CITY OF ALBUQUERQUE

**Planning Department
Transportation Development Services Section**

Re: Certification Submittal for Final Building Certificate of Occupancy for
Bldg Renovation & Addition @2910 San Mateo, [H-18 / D067]
2910 San Mateo Blvd NE
Architect's Stamp Dated 02/19/09

Re: **Permanent Certificate of Occupancy for Building Renovation and Addition at
2910 San Mateo Boulevard NE.**

C103

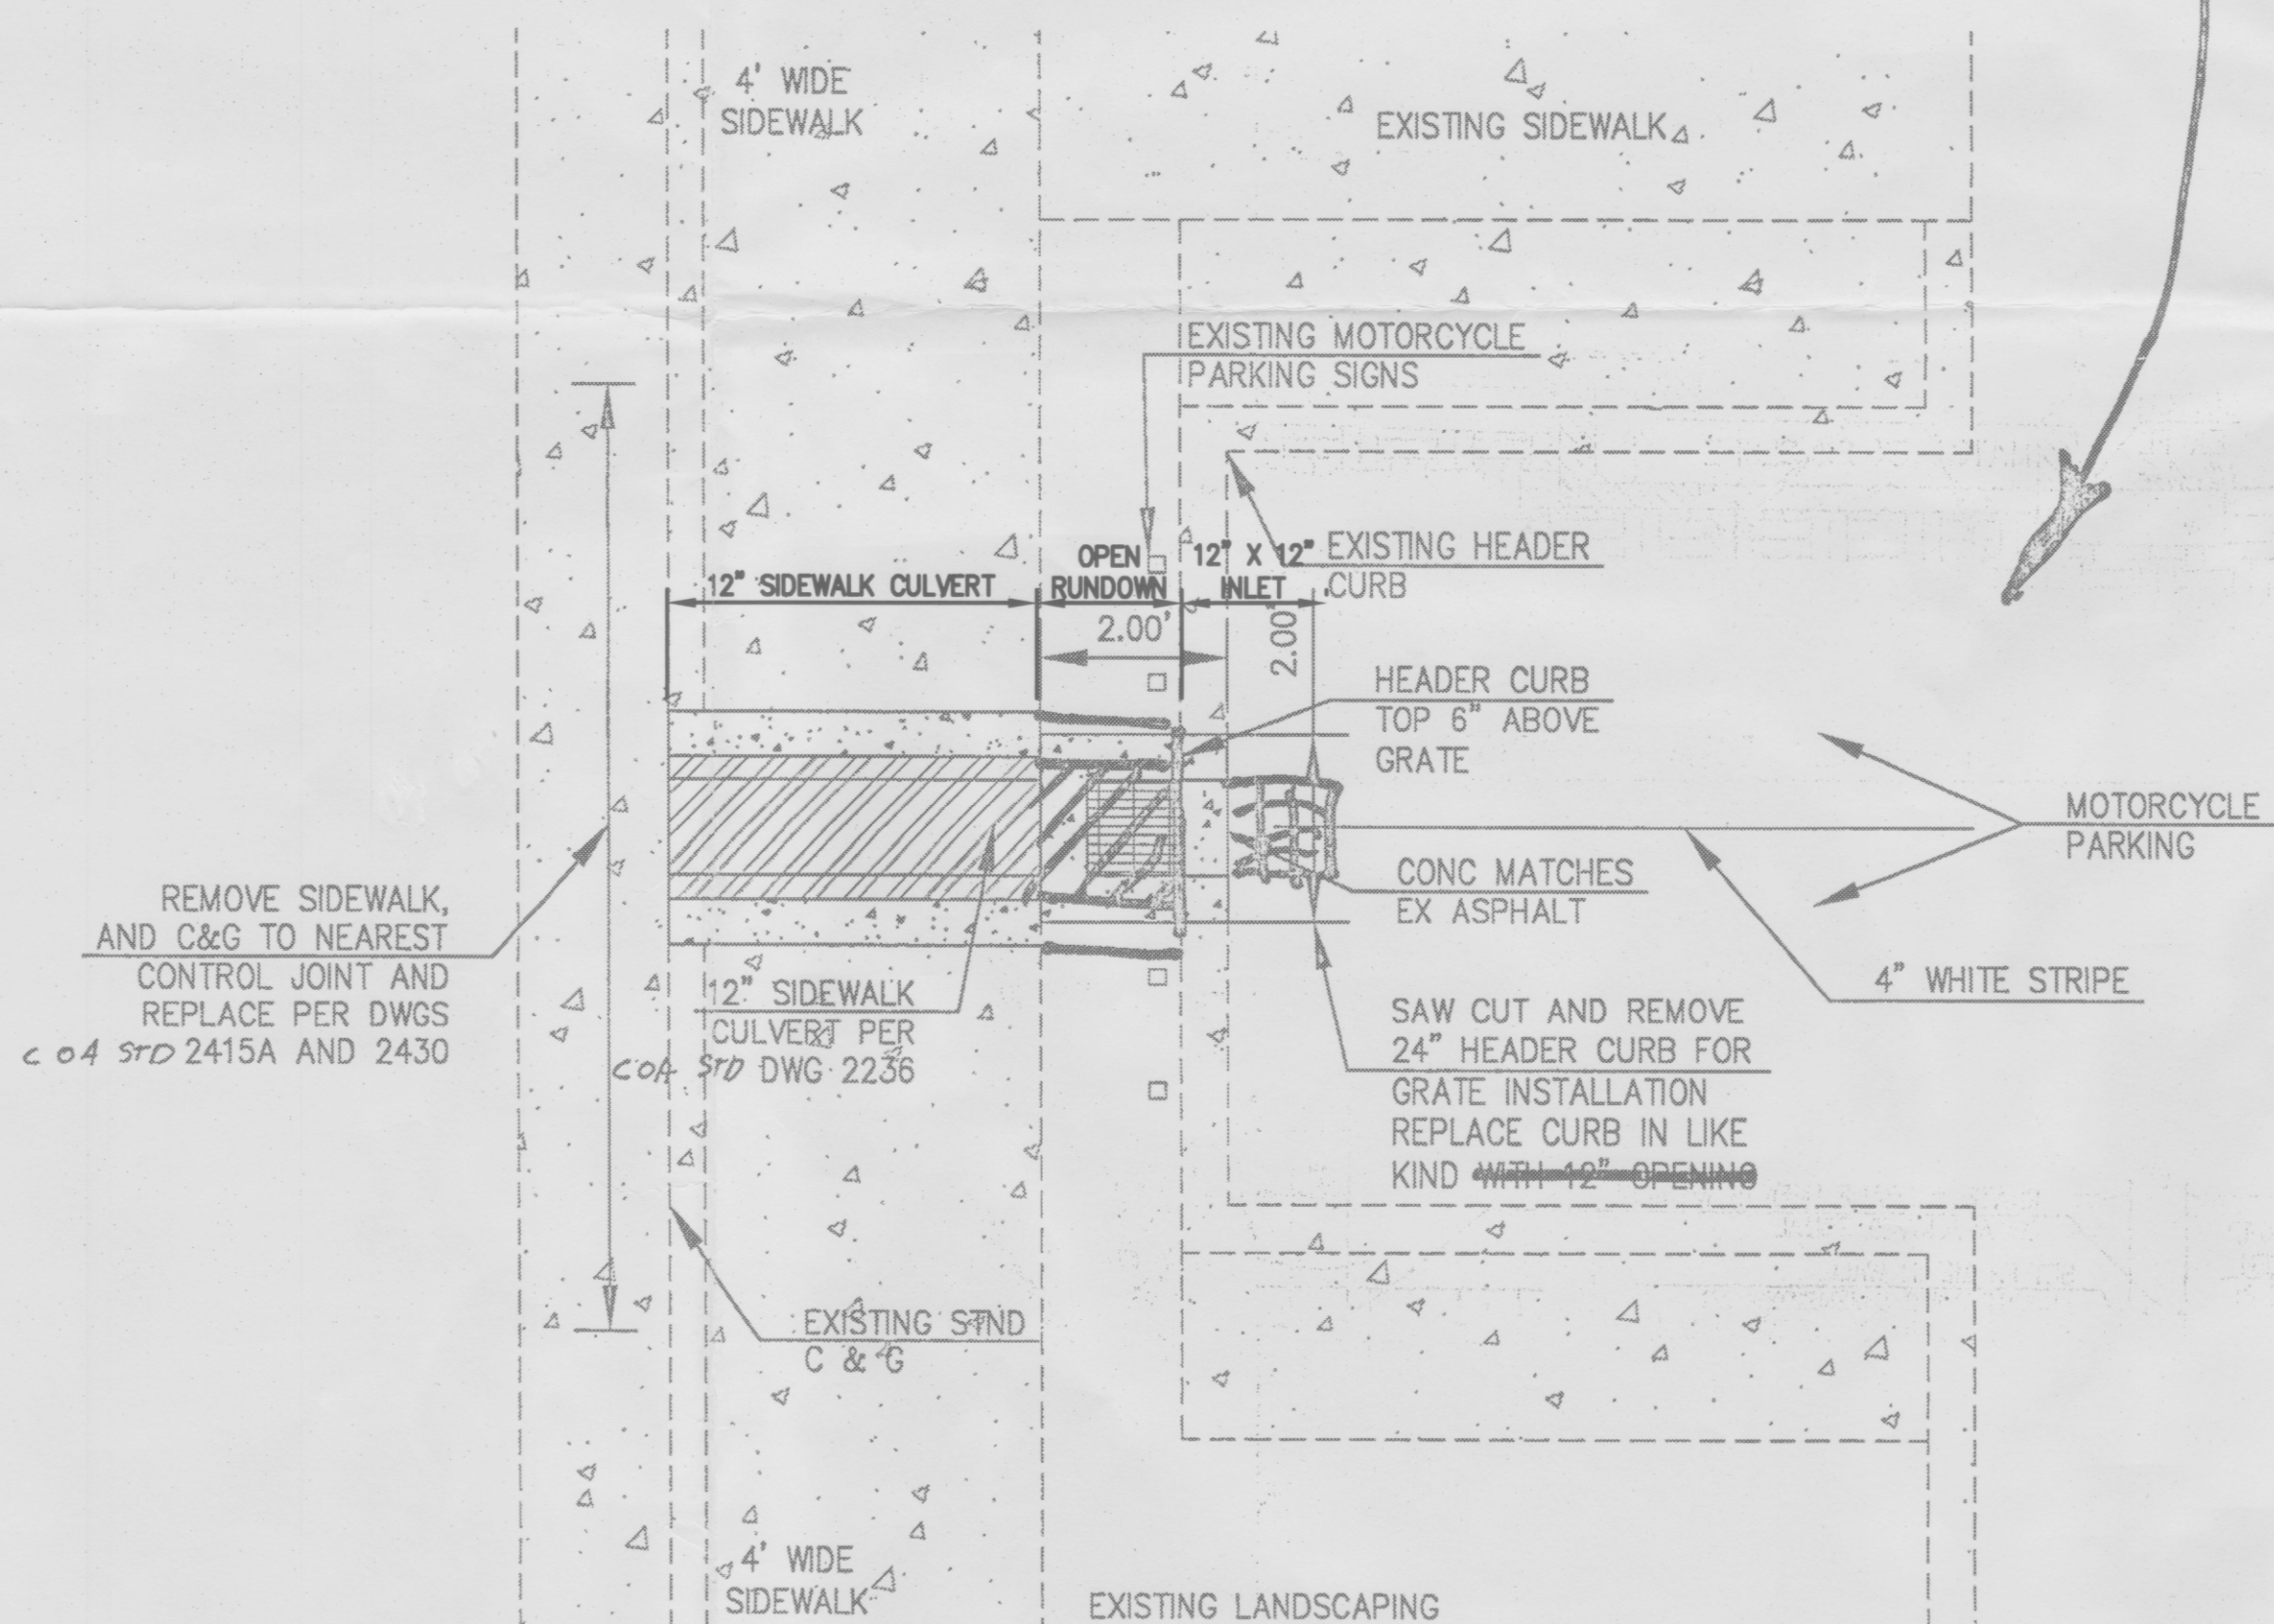
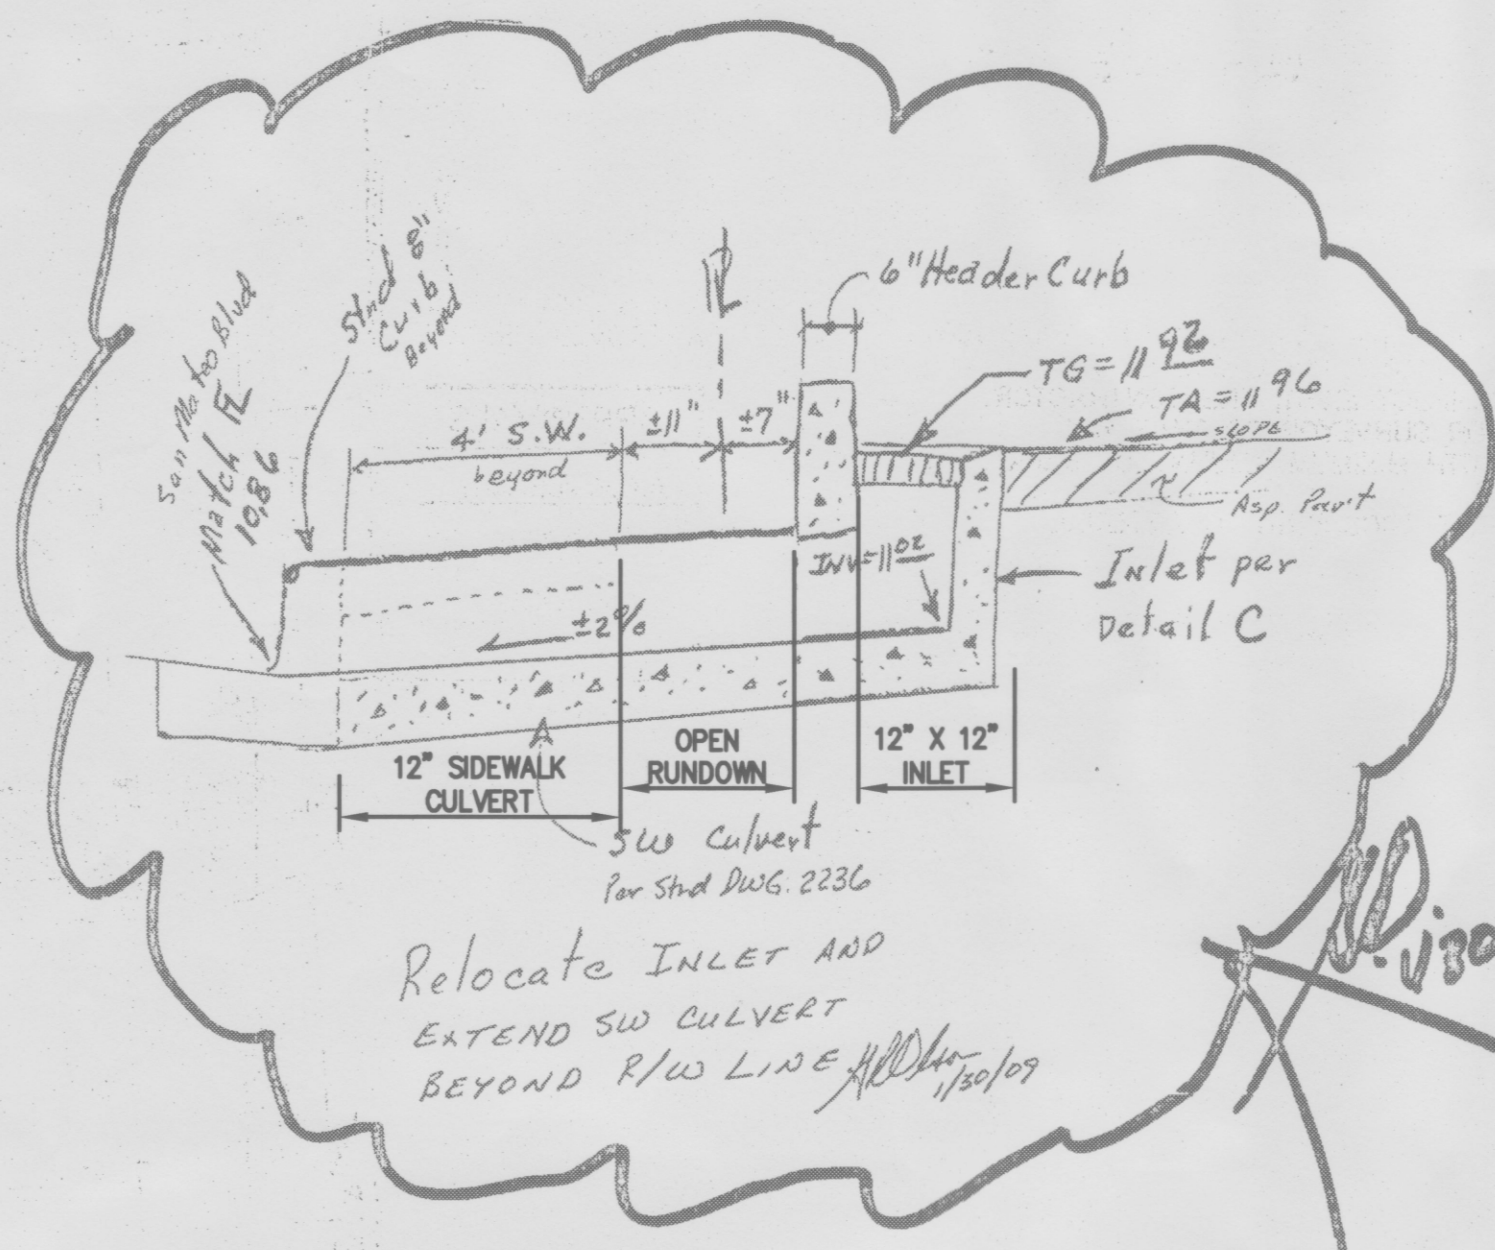
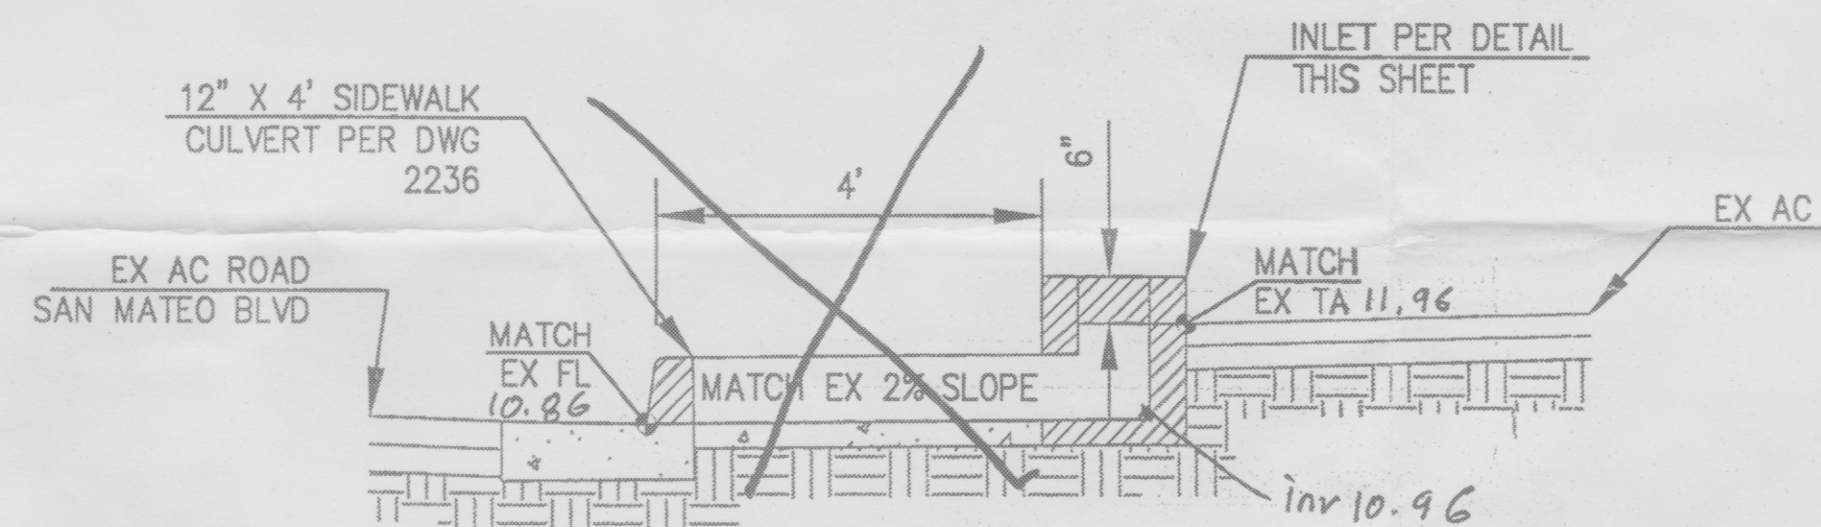
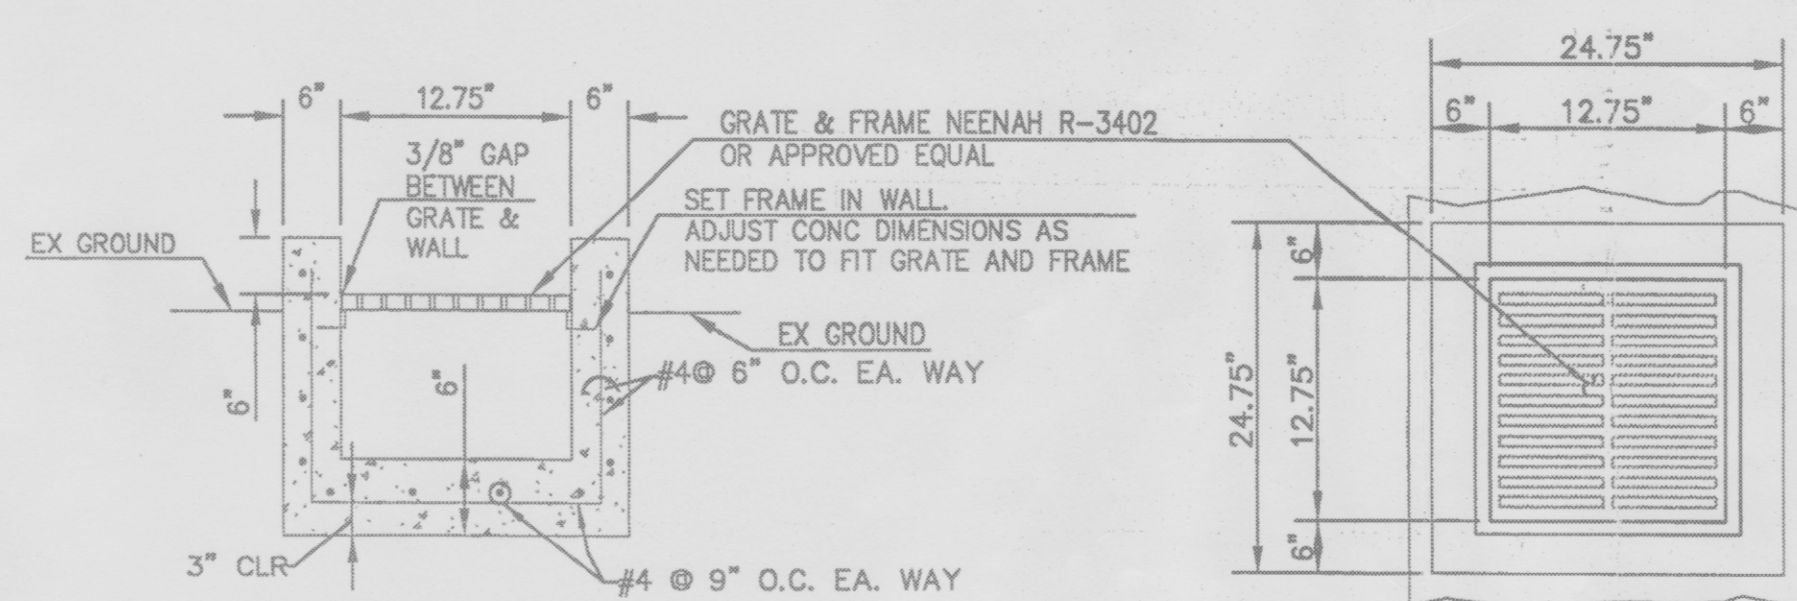
Based upon our telephone discussion, the original inlet location encroached on the public R/W for San Mateo Blvd. The inlet must be shifted east of the Property Line and the Sidewalk Culvert extended to the inlet wall (similar to detail attached to plan).

Relocate INLET AND
 EXTEND SW CULVERT
 BEYOND R/W LINE
 1/30/09

The As-Built configuration of this added drainage feature must be incorporated into your final Drainage Certification submittal for Certificate of occupancy.
